REFUSAL OF PLANNING PERMISSION

Application Reference: DC/20/00144

Full Planning Application - Change of Use from Agricultural Barn/Business Store to 1No Dwelling.

Christmas Tree Barn, Mill Lane, Weybread, Diss Suffolk IP21 5TP

Figure 1: Existing Elevations

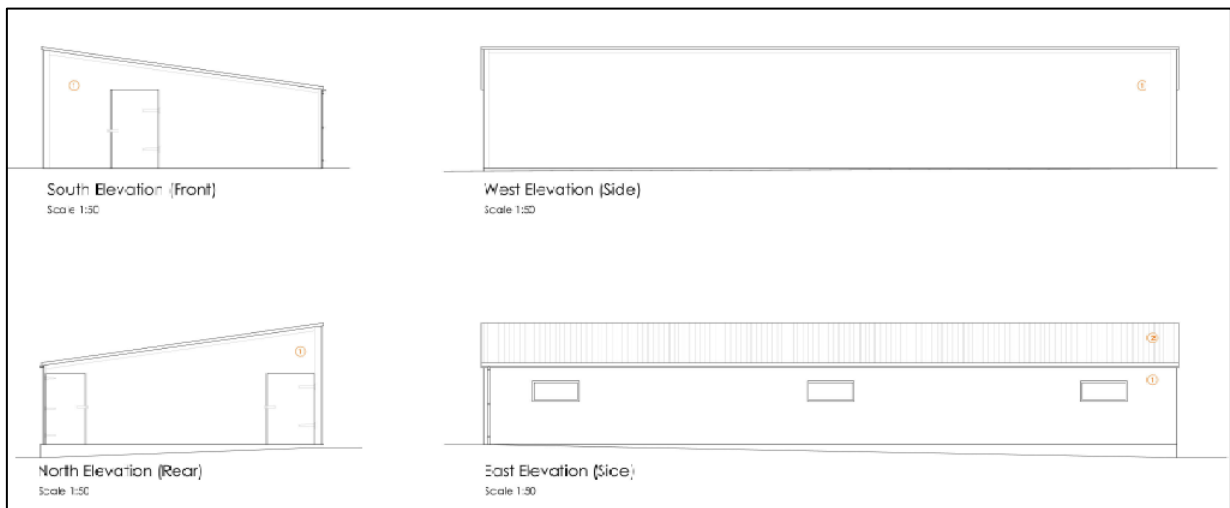
The subject building is a basic mass and shape with a mono-pitched roof and timber frame on a thin concrete pad, with cement sheeting on the roof and clad in plywood sheets with no openings other than a double door of plywood on hinges. The proposal relates to a building that has no character that would be desirable to be retained. Its form, bulk and design are modest in scale but offer no personality or charm. Furthermore, policy H9 requires that 'new openings should be kept to a minimum to retain the existing form', as the existing building only has a door the proposal requires 8 new openings and bi-folding doors would extend across one whole elevation.

The shed's form, bulk and general design is considered to be out of keeping with its surroundings, lacking character and architectural merit that would justify its conversion under policy H9.

Figure 2: DC/20/00144 Proposed Elevations

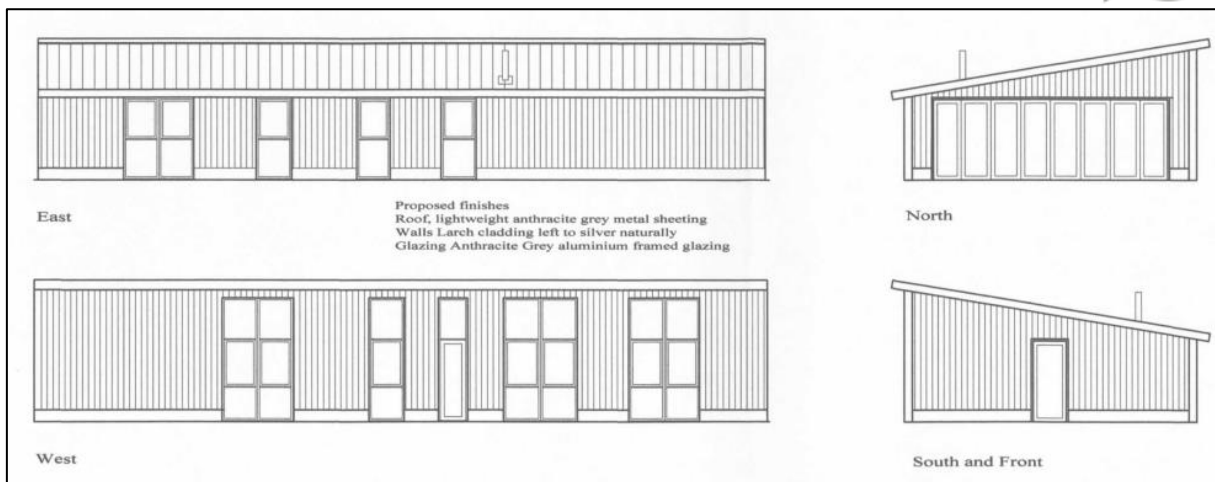
The building offers no desirable character to justify its conversion and therefore does not meet the standards and criteria of policy H9 and offers a large number of new openings.
